# TIERRA WEST, LLC

April 29, 2024

**RE: 2022031 LOVES SUNPORT BLVD  
ALBUQUERQUE, NEW MEXICO**

CONDITIONS OF APPROVAL –SI-2023-00691

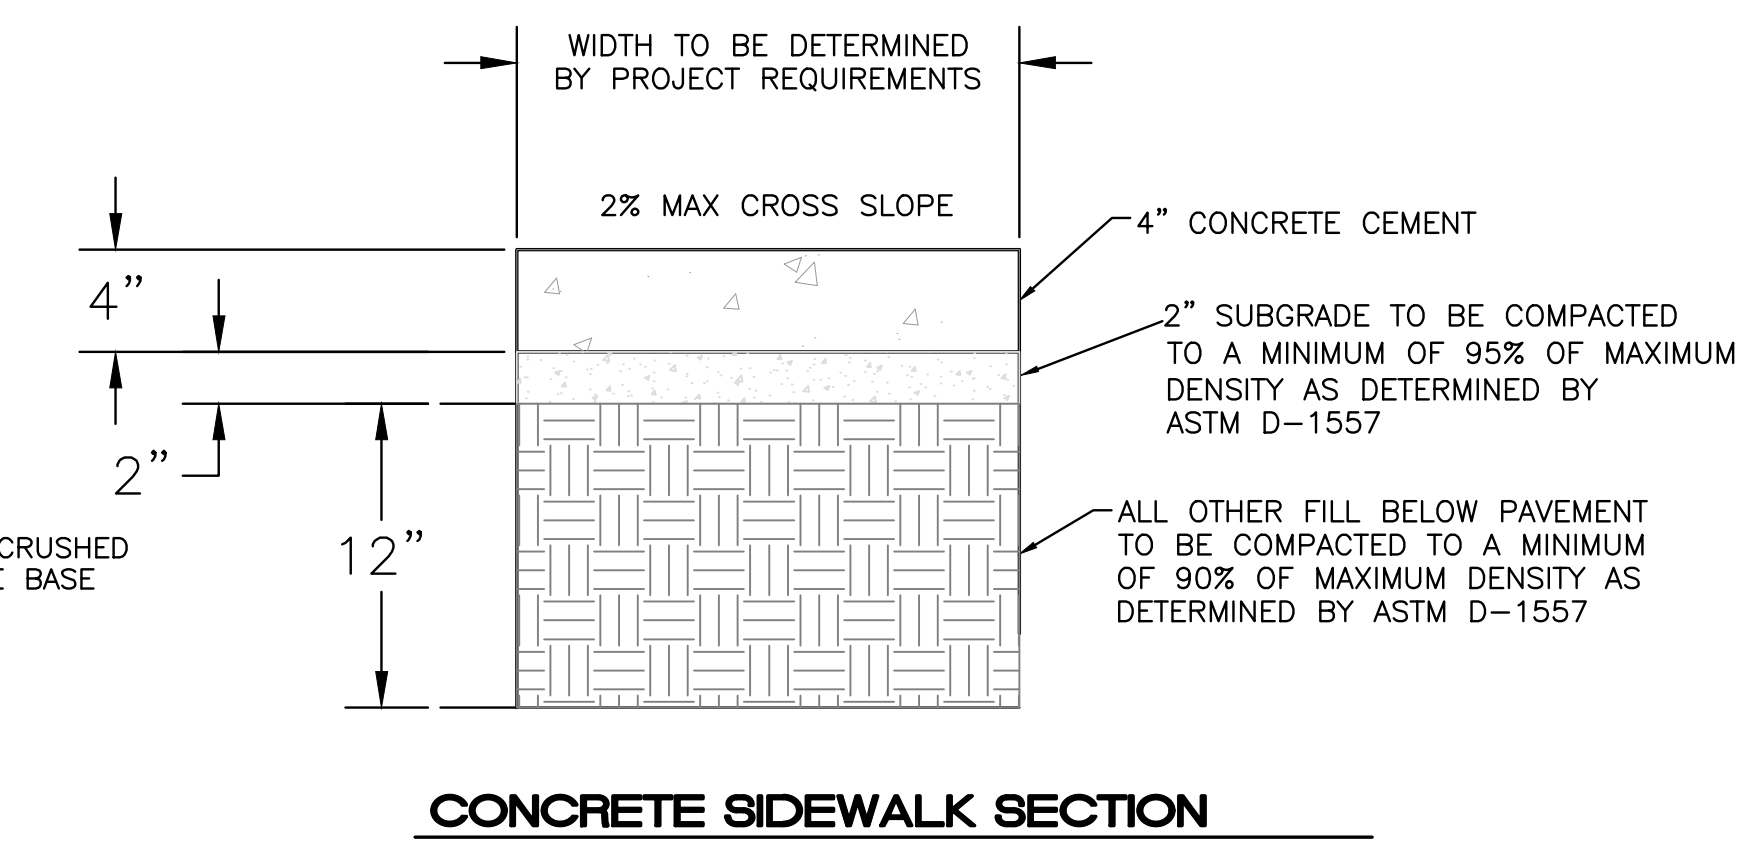
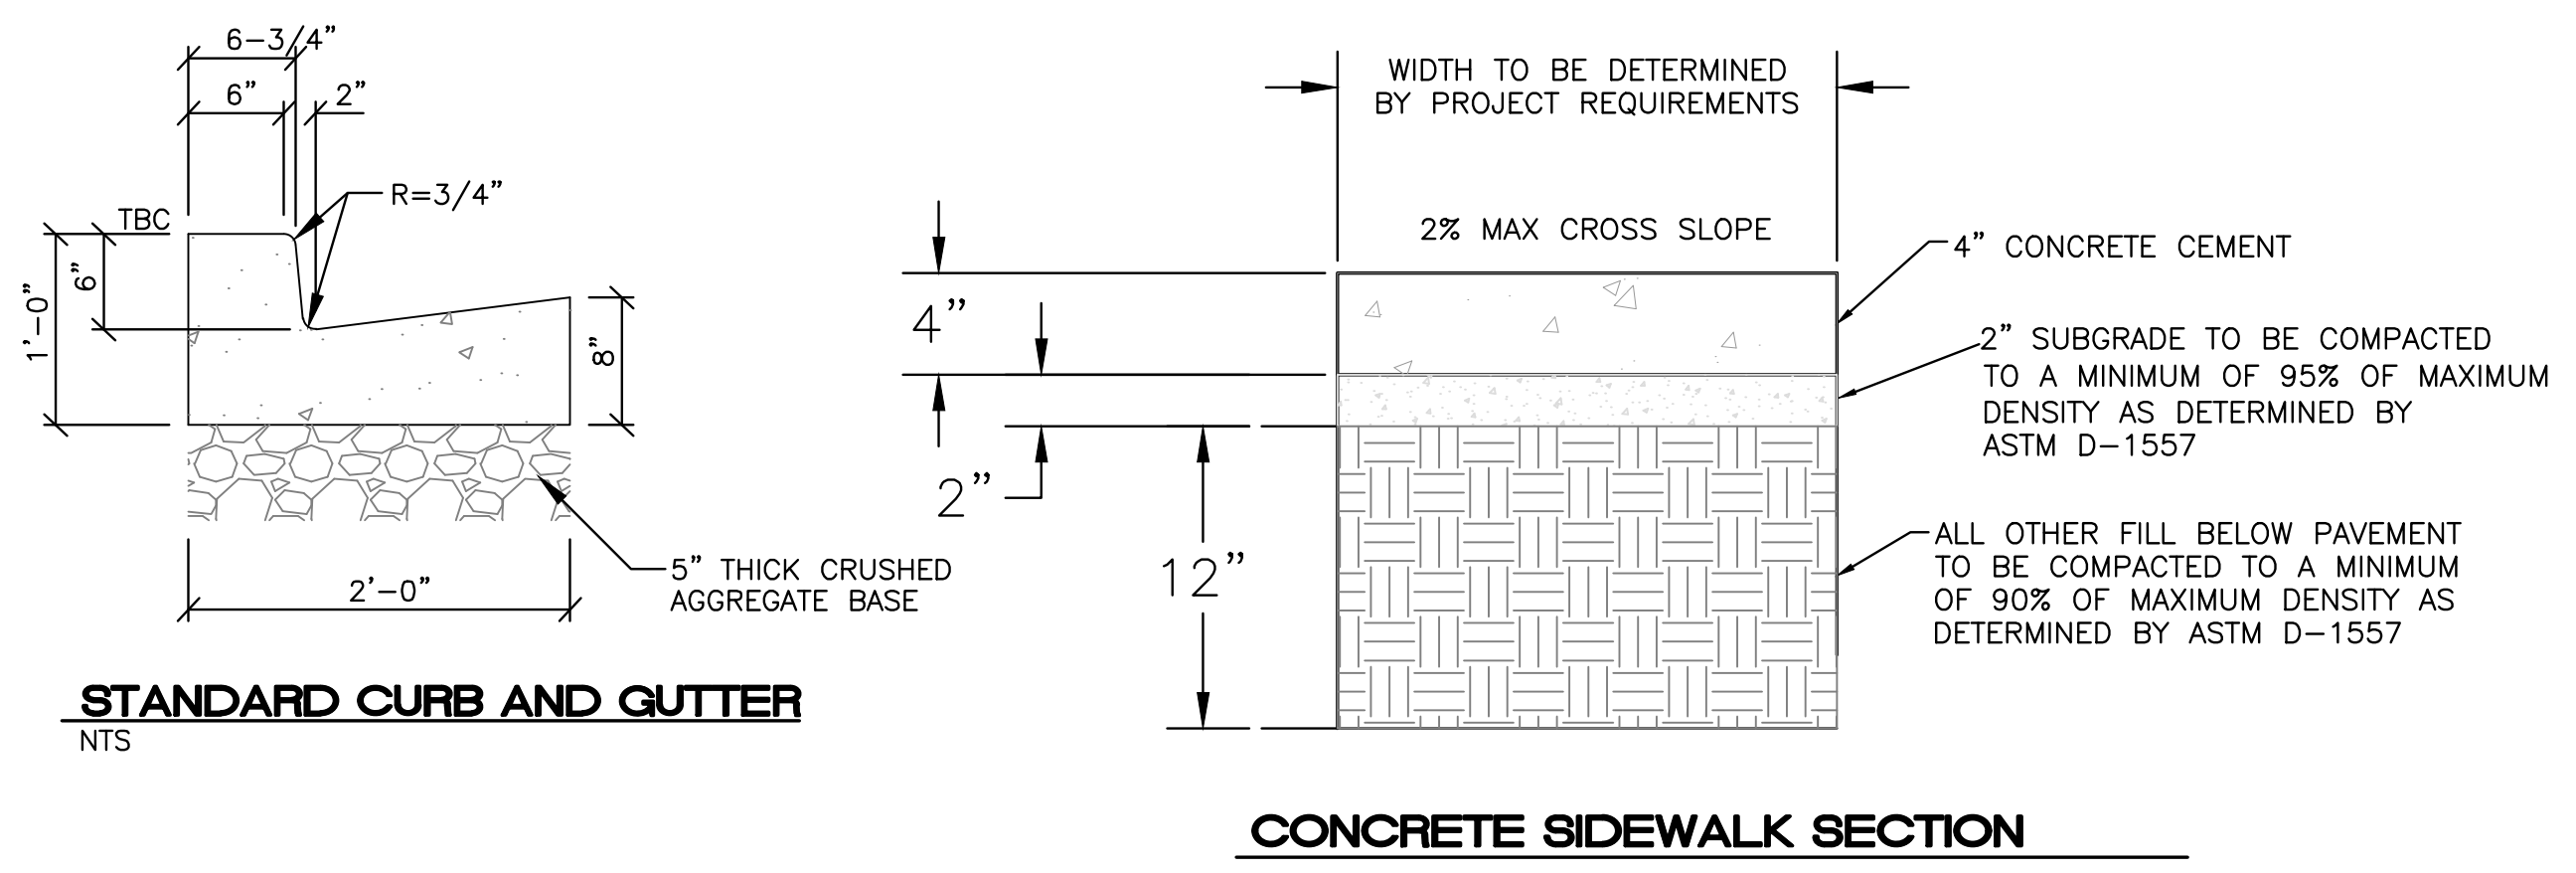
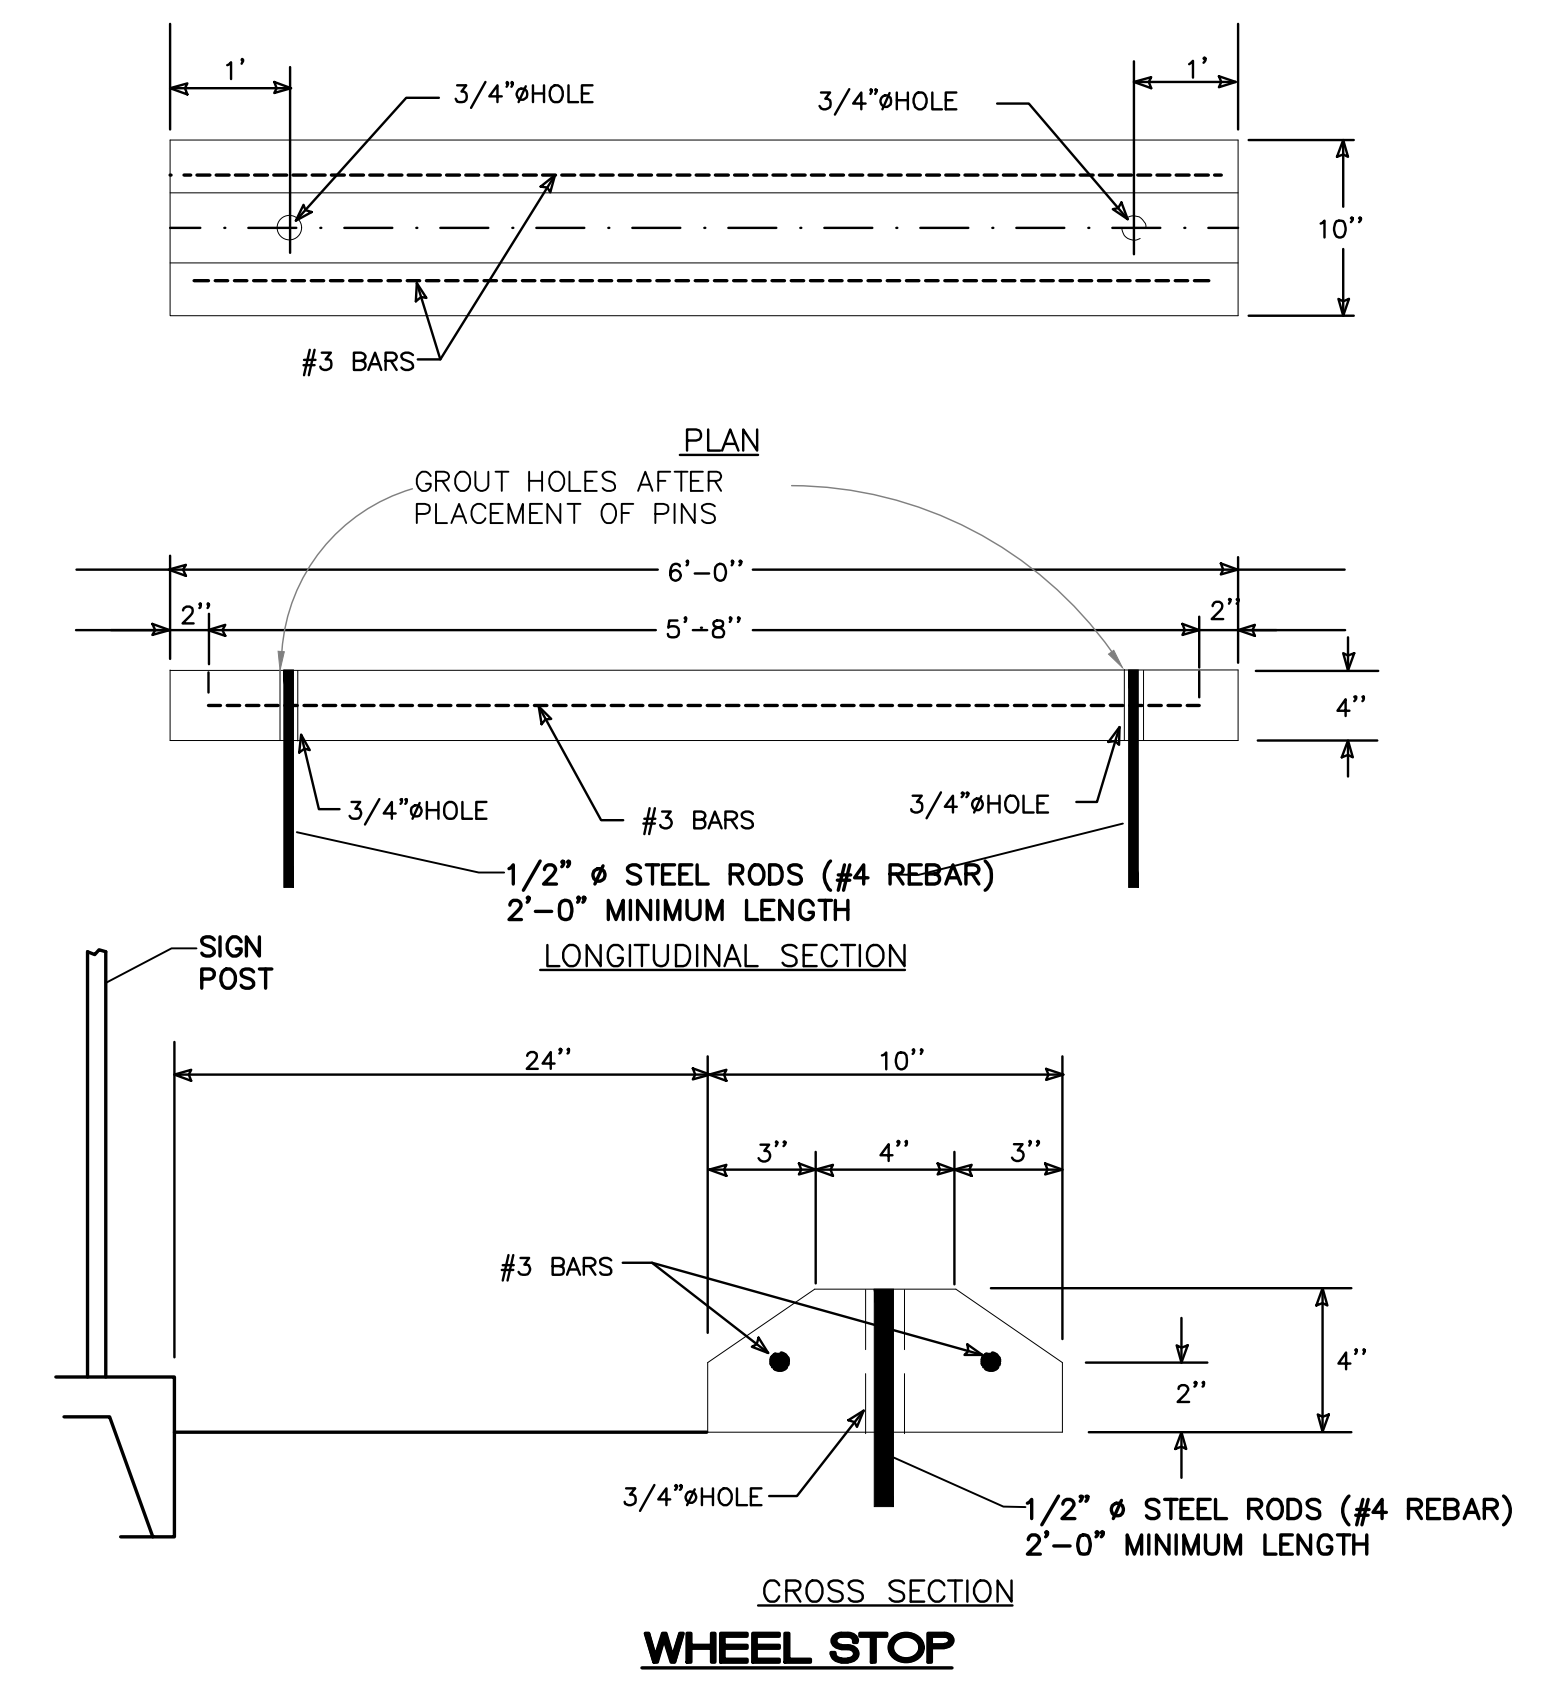
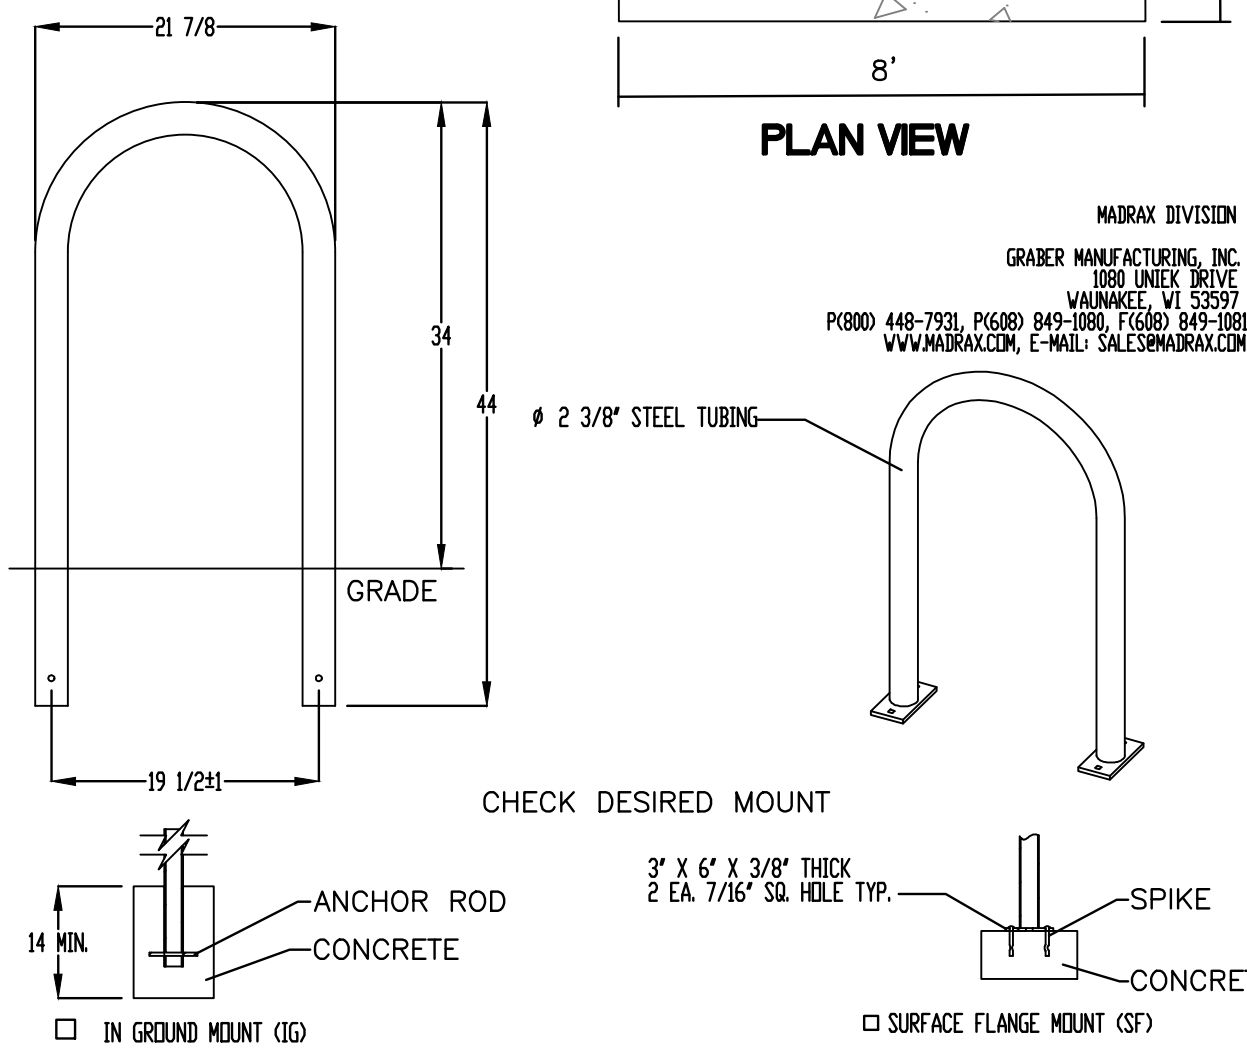
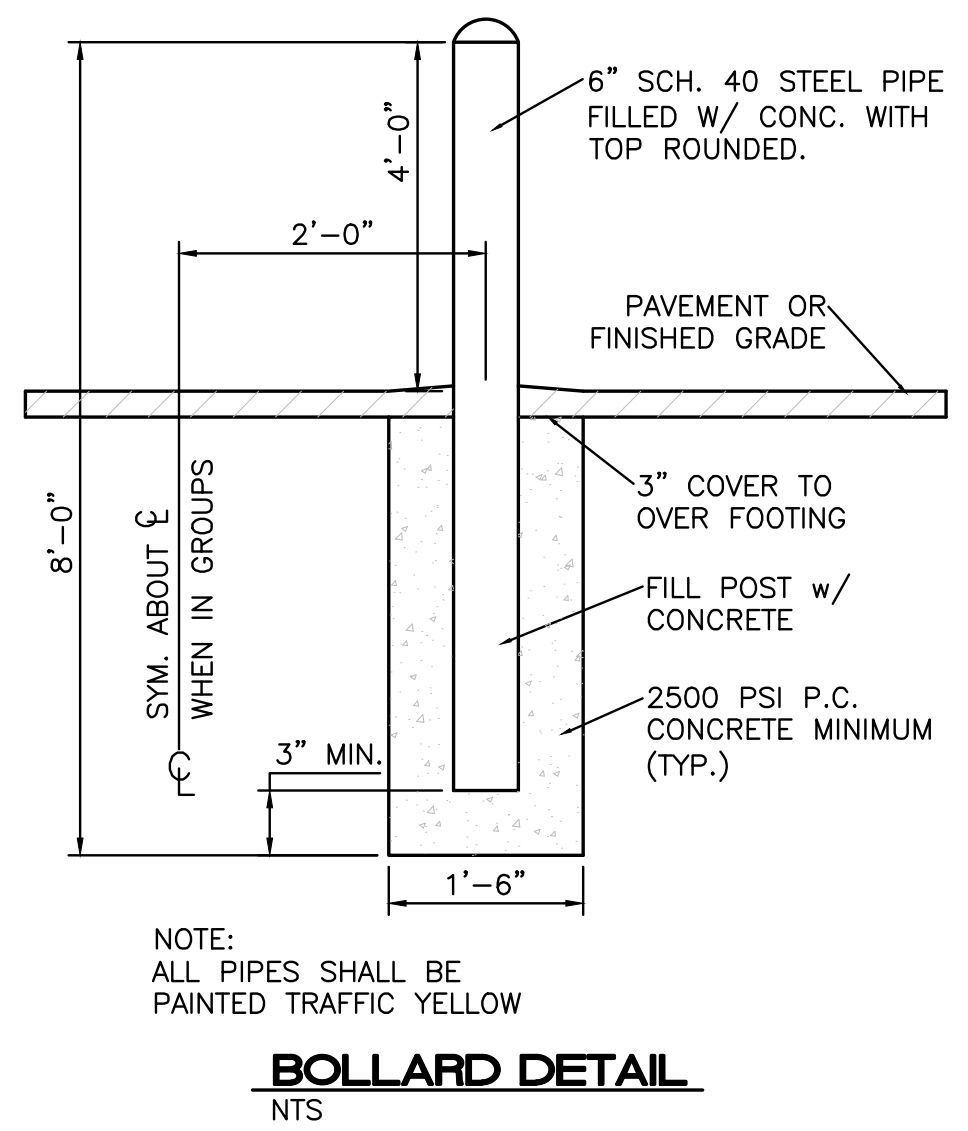
- a. Parking Lot light poles and light details pursuant 4-3(D)(17)(d) shall be included.

**Parking lot light pole detail was added to the Site Plan set (DET-1).**
